Comments for Planning Application APP/20/01529/F

Application Number: APP/20/01529/F

Address: 7 Labrador Drive, Poole, BH15 1UX

Proposal: Remove existing first floor door and window and replace with a Sliding Patio Door, Upgrade the Balcony Glass unit present fitted so it is more glass and less frames and build a storage unit which is between the existing extension and the Garage.

Proposed Property Layout:
7 Labrador Drive
Baiter Park
Poole
BH15 1UX

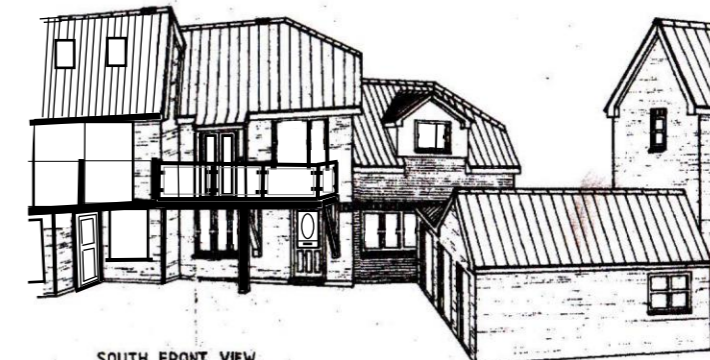
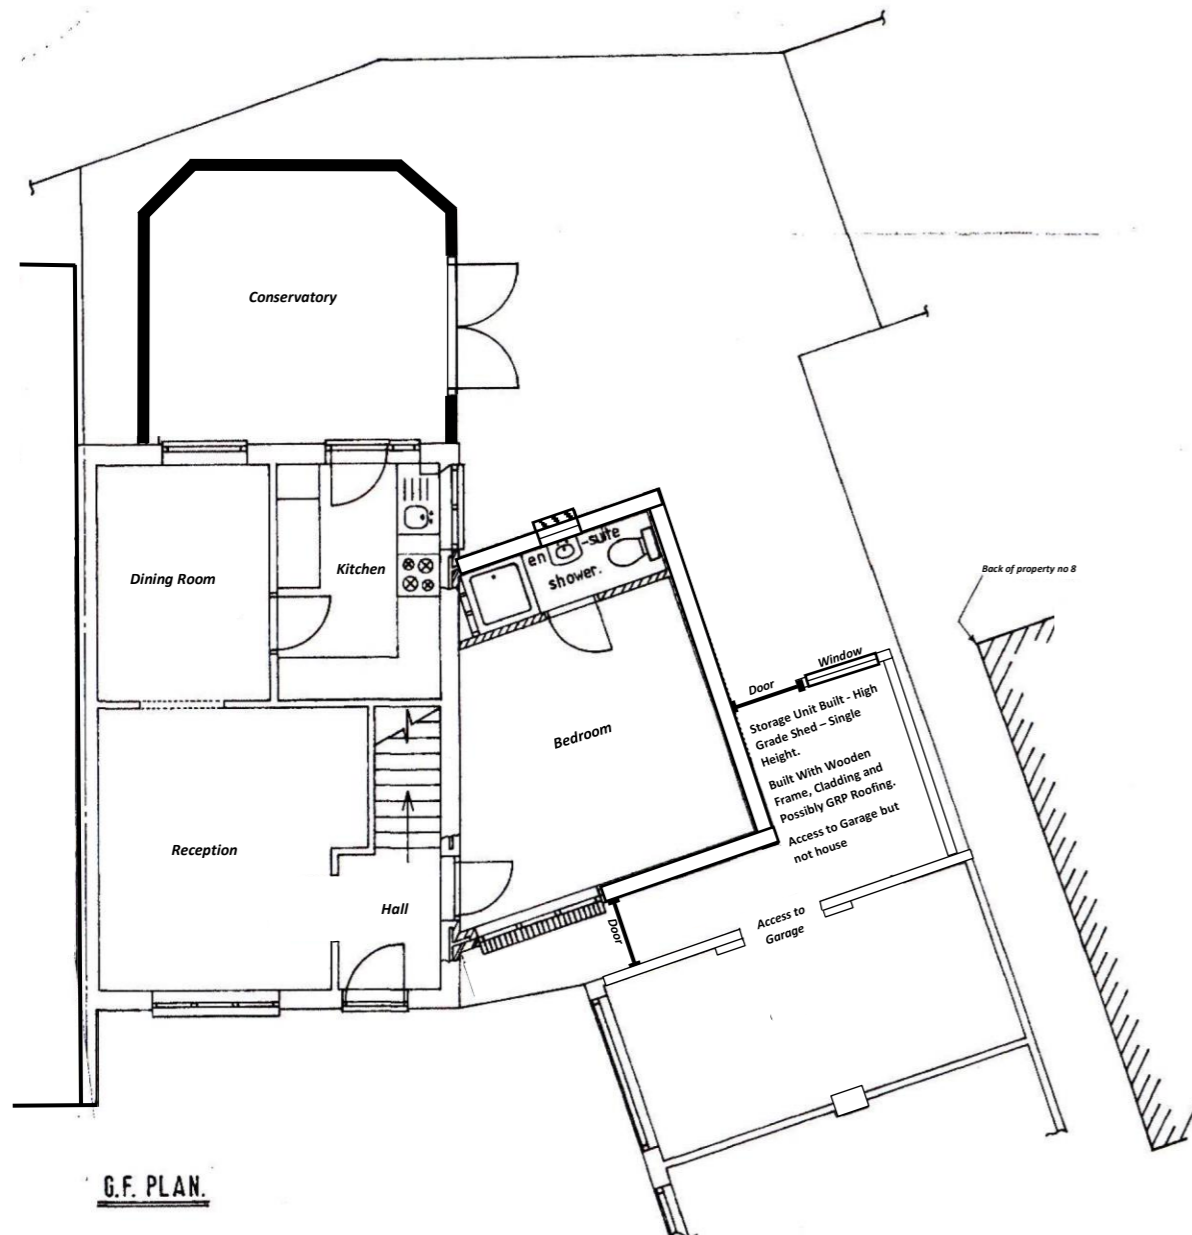
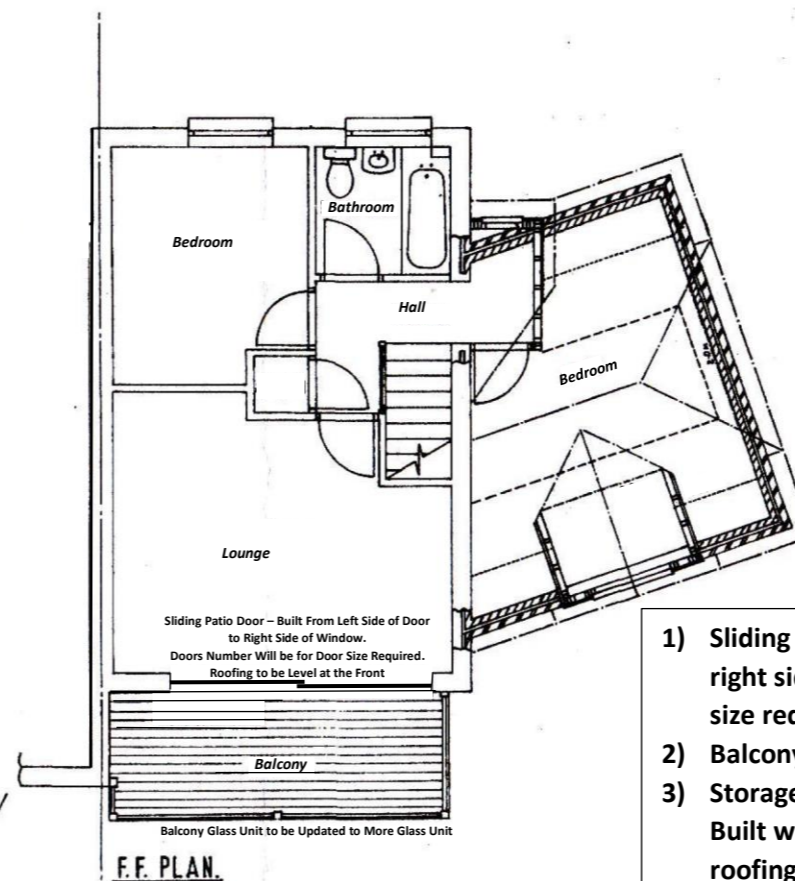
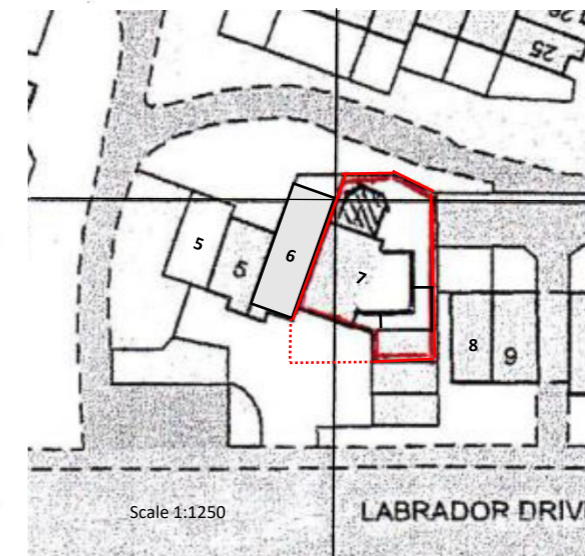
1. Our neighbours are Mark and Penny Hockey, who own and holiday let this property. Who is Mark Farthing ?
2. The existing and proposed drawings are virtually the same with no details of proposed balcony, new patio door, 'shed' and mentions a retrospective application for a conservatory at the rear. .. have the wrong documents / names been uploaded ?
3. That the balcony and a Sliding Patio Door matches local colours ie dark brown/black/clear and NOT white as it is at the moment, and planning conditions for this area.
4. That the shed structure that seems to be close to No. 8 boundary does not damage the fence or allow overspill across the boundary - ideally the wall of the shed should be put say 6" away from the fence.
5. That our tenants living in Number 6 and No. 8 are not disturbed or inconvenienced and are kept fully informed.
